Our ref: 20050175

Your ref: EN010125

Date: 23 May 2025

Dogger Bank South Offshore Wind Farms Project: Environment Agency response to Issue Specific Hearing 4 Action Points (Deadline 5) and Examining Authority's further written questions and requests for further information (ExQ2)

Title:
Watercourse Crossings (Main Rivers and ordinary watercourses)

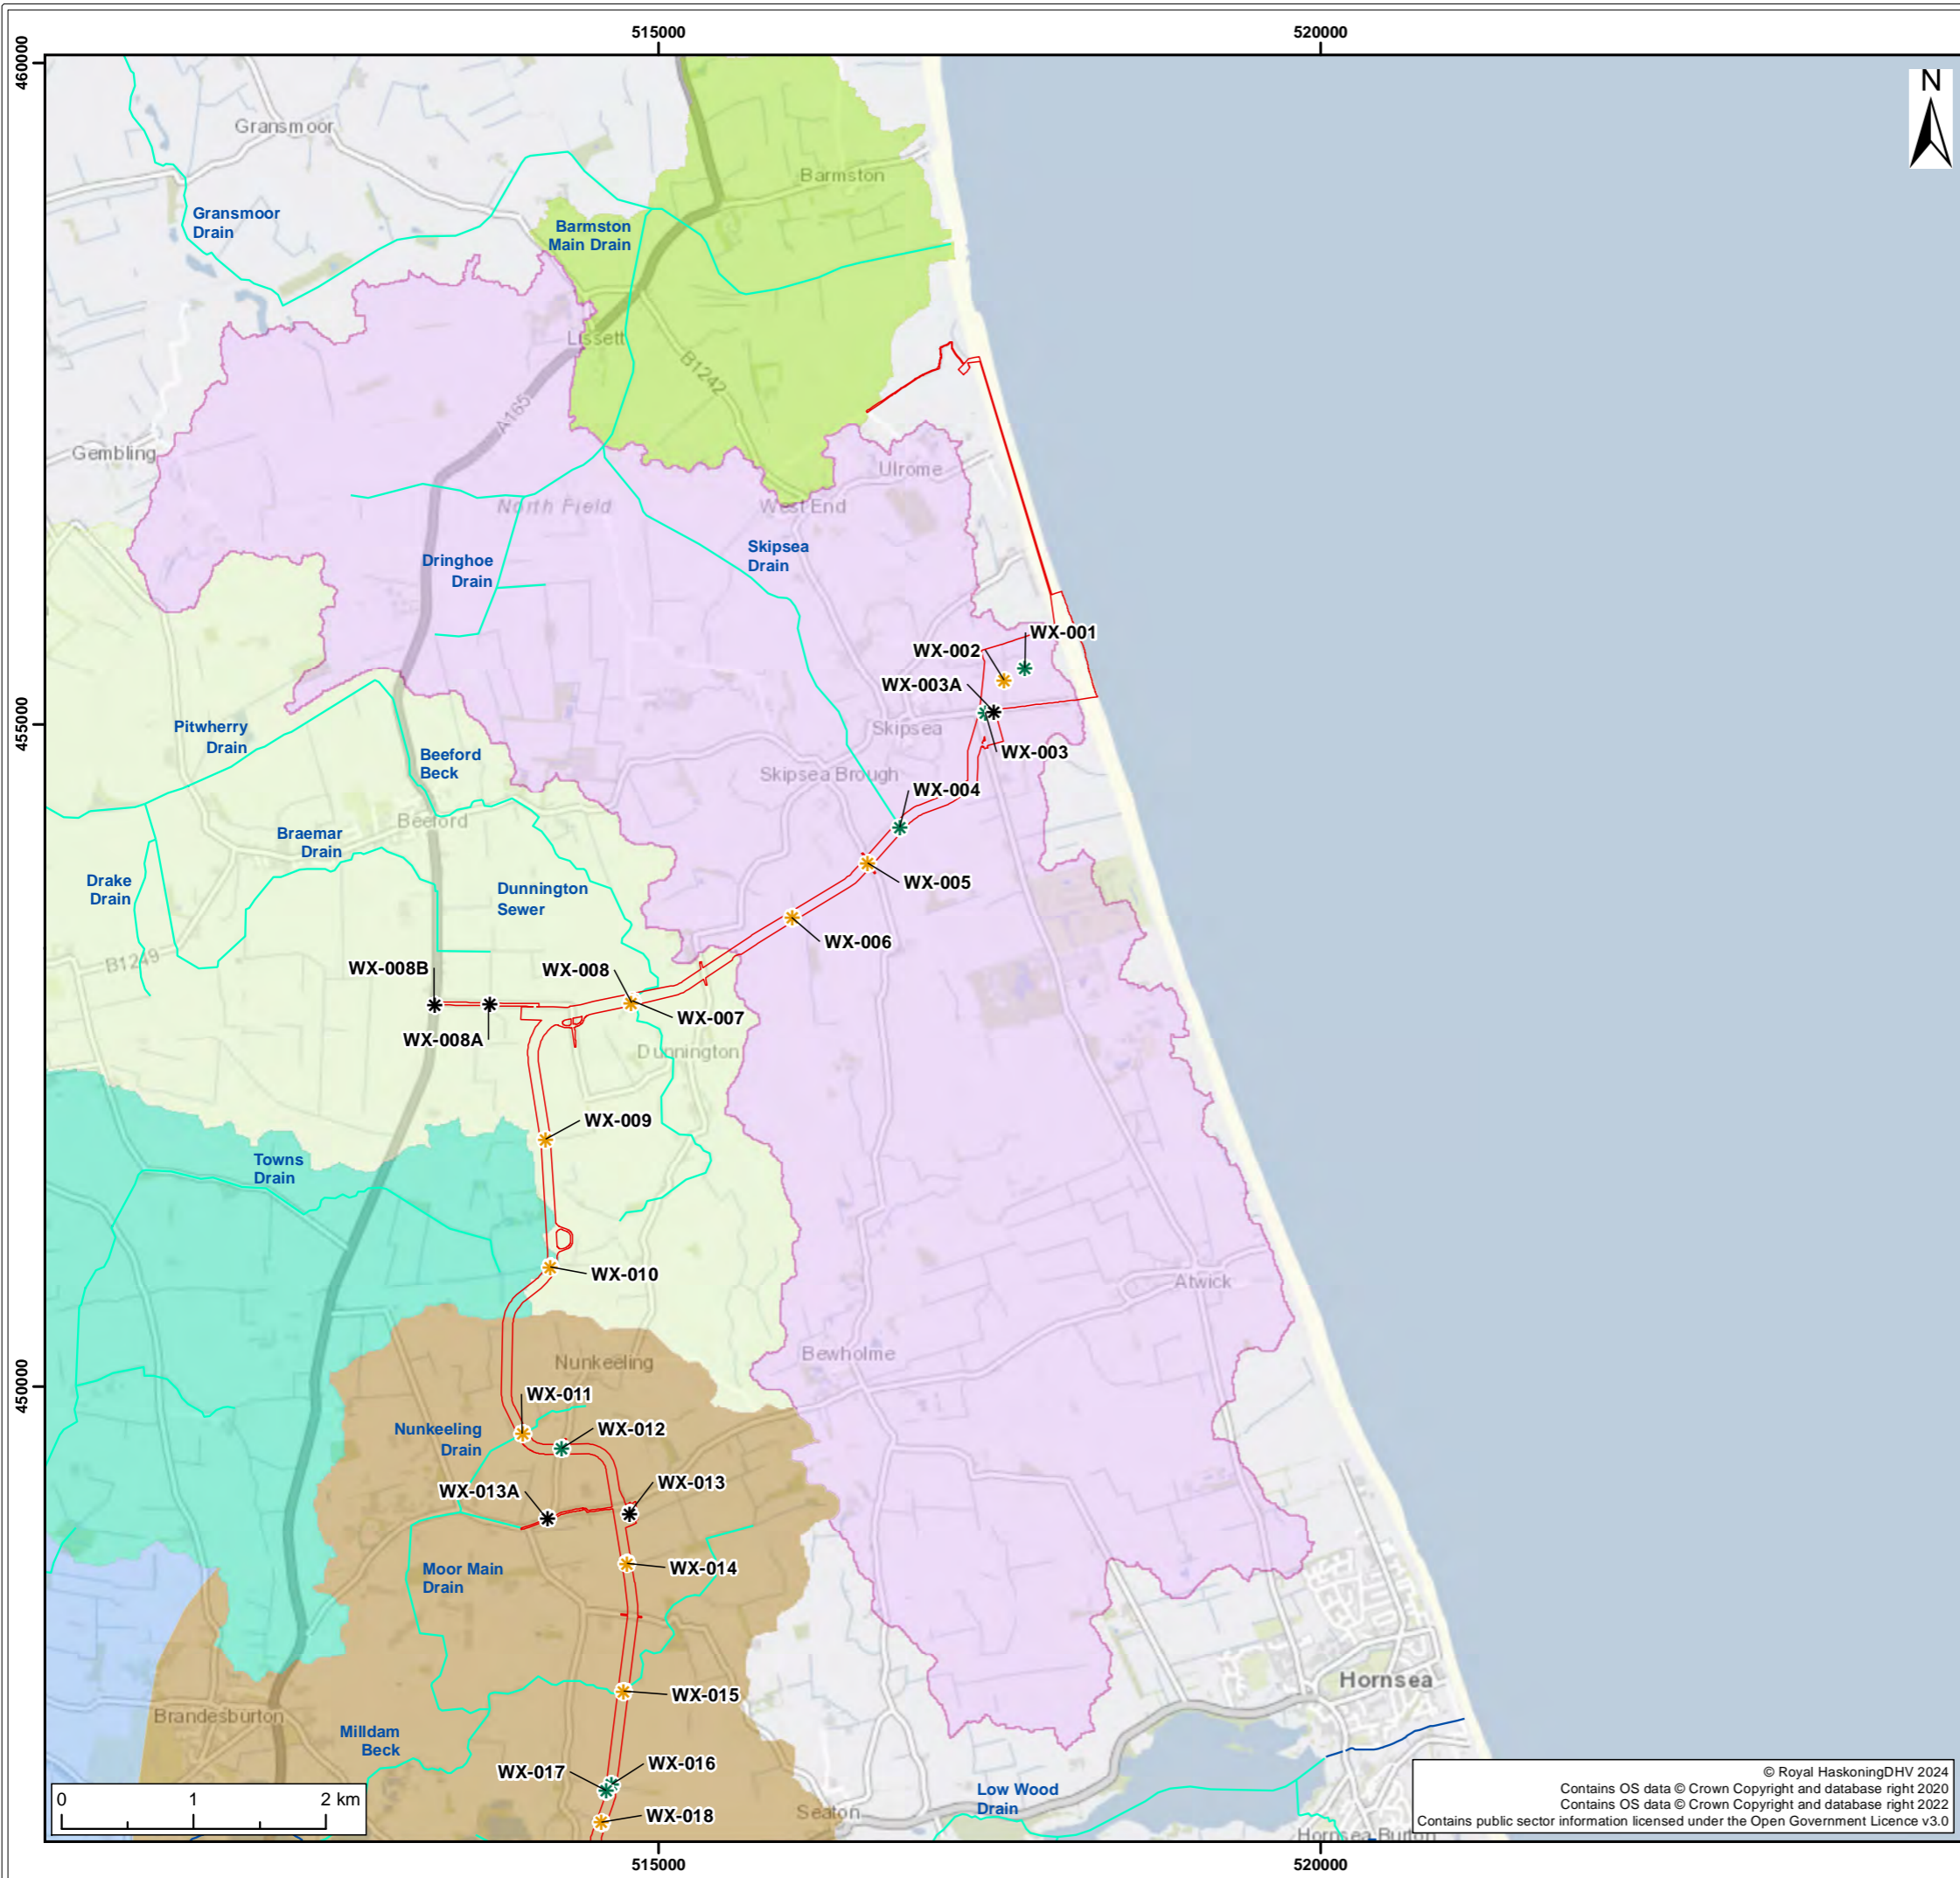
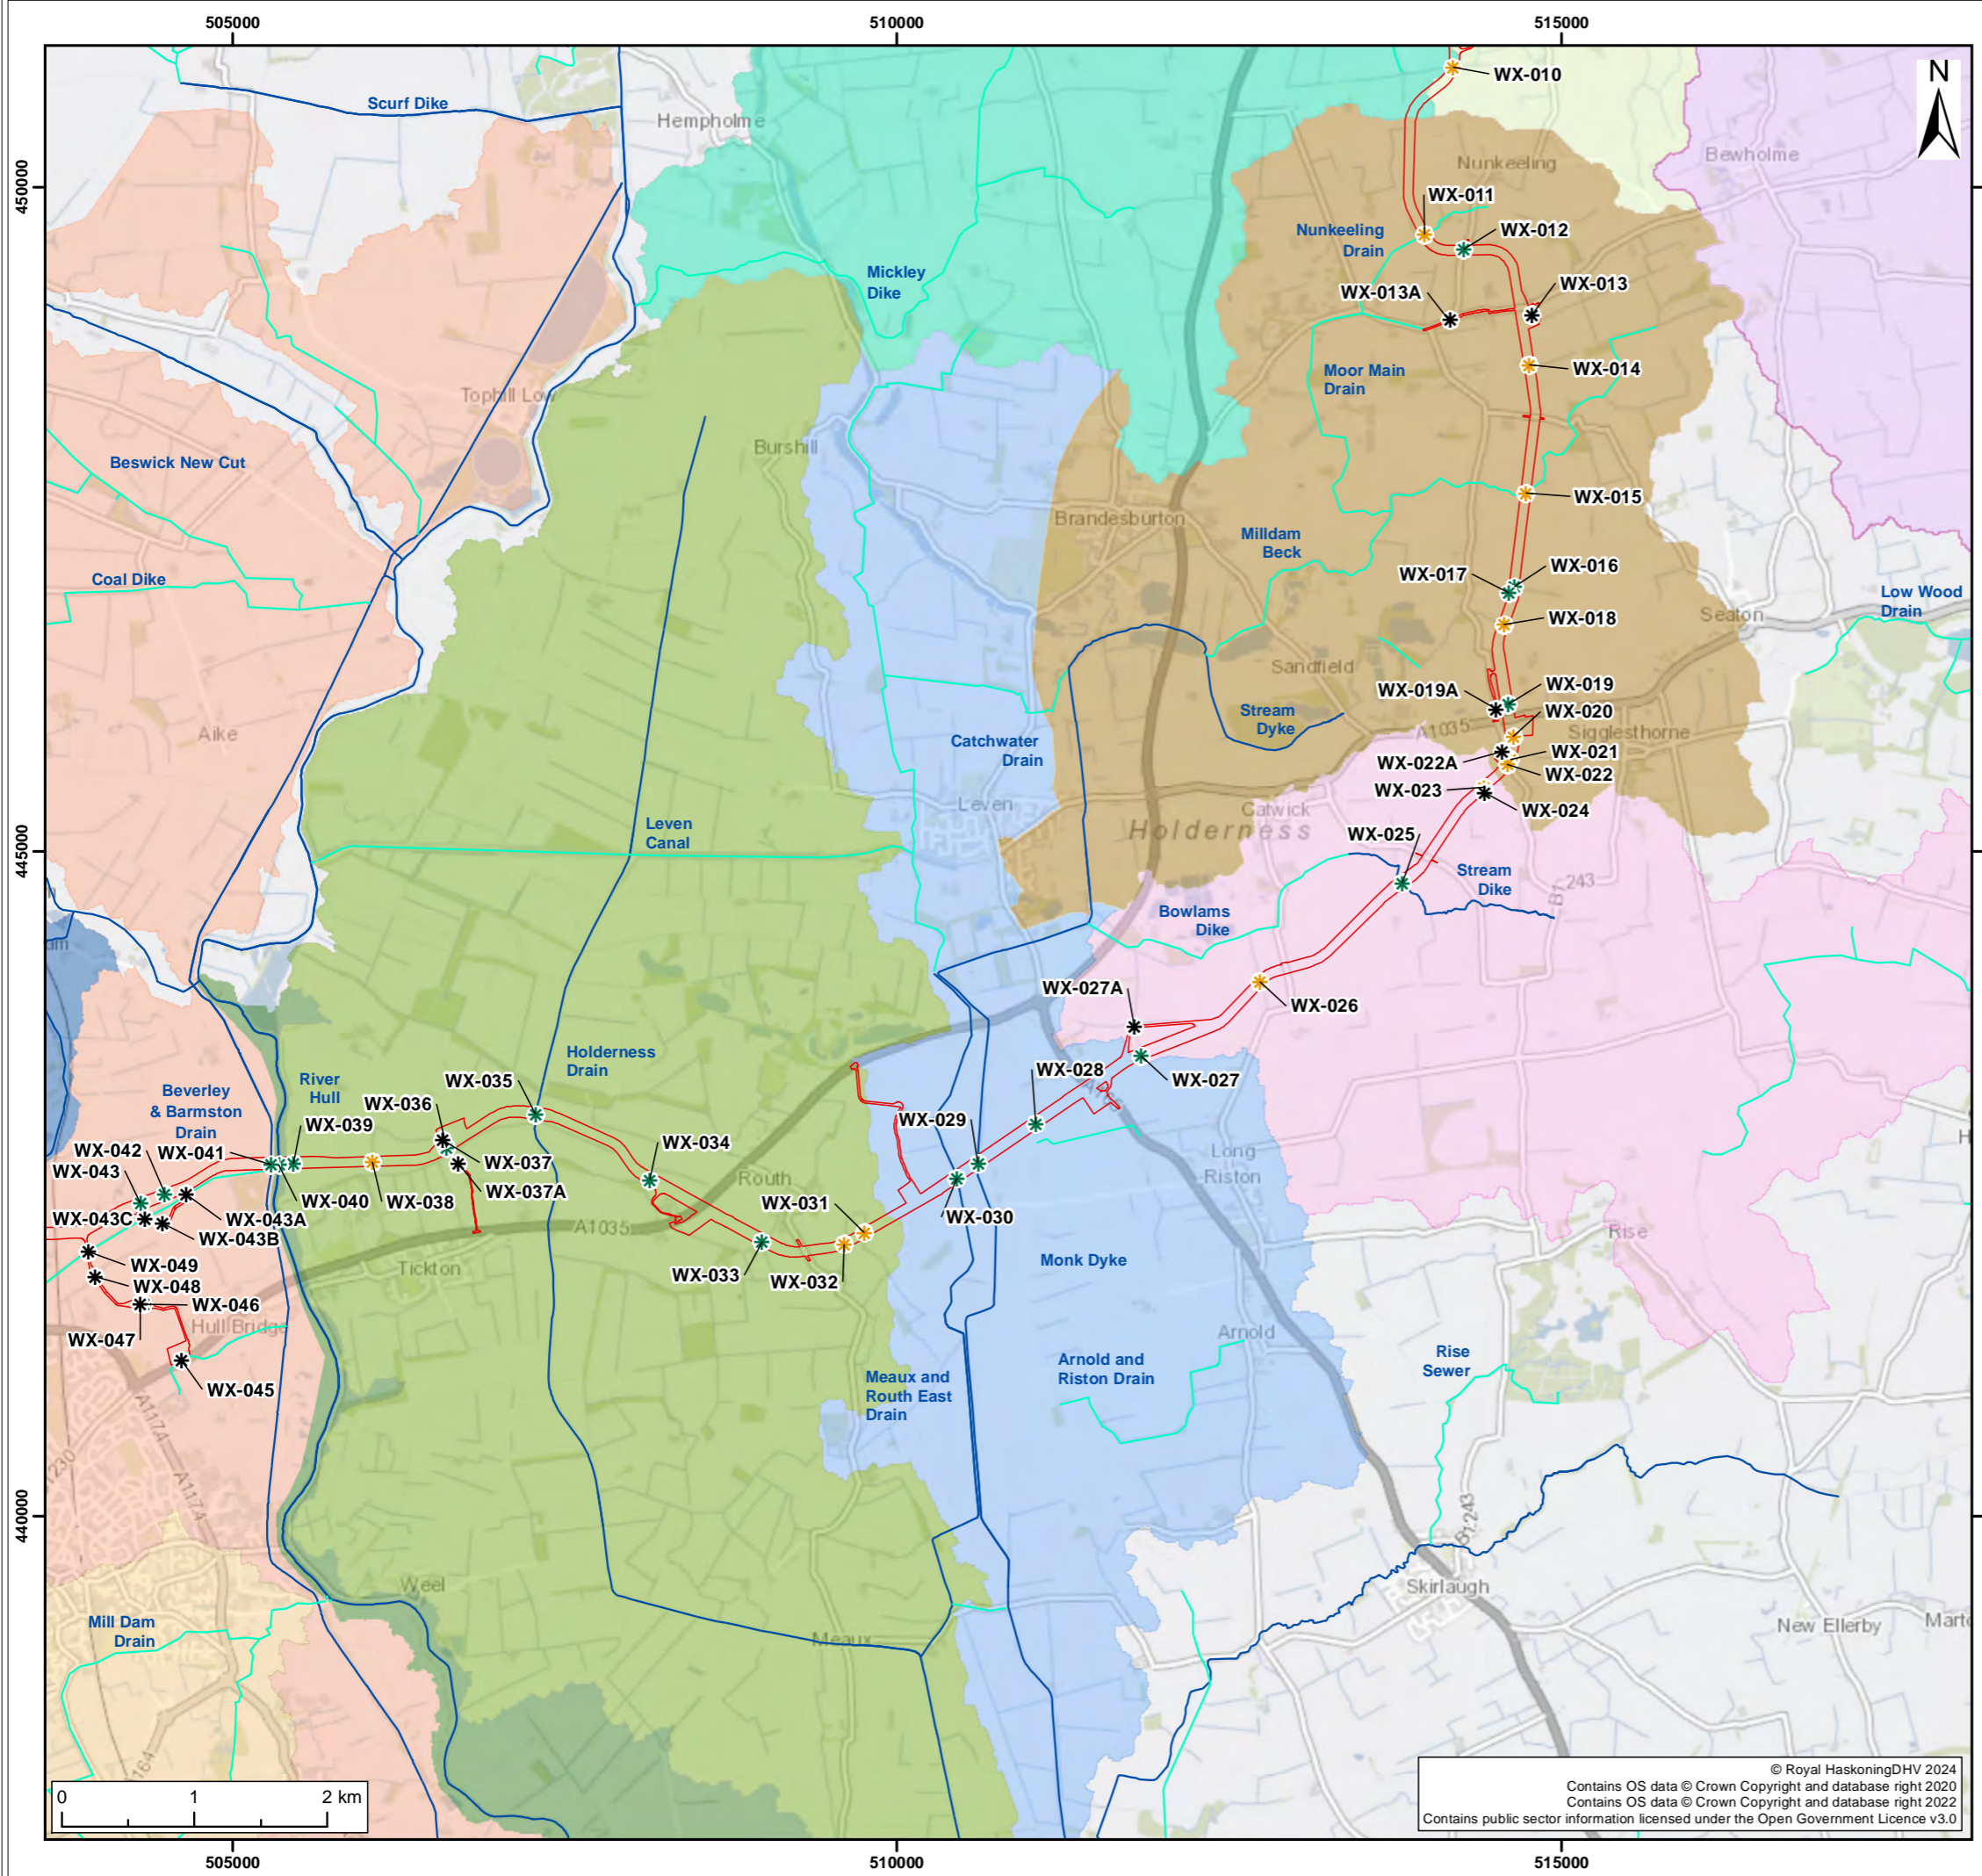
We are only aware of one temporary crossing on Main River, and that will be a temporary culvert on Meaux and Routh East Drain. For completeness we have included our answer to ISH4 Question 8 here:

*8) To confirm its position on the proposed watercourse crossings Wx-029 and Wx-030 and the associated environmental impacts [REP2-014] **Deadline 4**
WX-029 will be clear span. The only additional requirement we have here is that the*

abutments for the crossing are located away from the embankment such that the clear span encompasses the bank on both sides of the watercourse.

WX-030 – *this will be culverted. In principle we do not object to the culvert crossing, though the culvert must be appropriately sized to pass a flood flow.*

We have let the applicant know that the Meaux and Routh East Drain channel is deep and steep sided so it may be difficult to reinstate the channel when the culvert is removed.

In relation to all watercourse crossings whether clear span or culverted we would expect that the sites are reinstated to the existing conditions once the temporary crossings are removed.
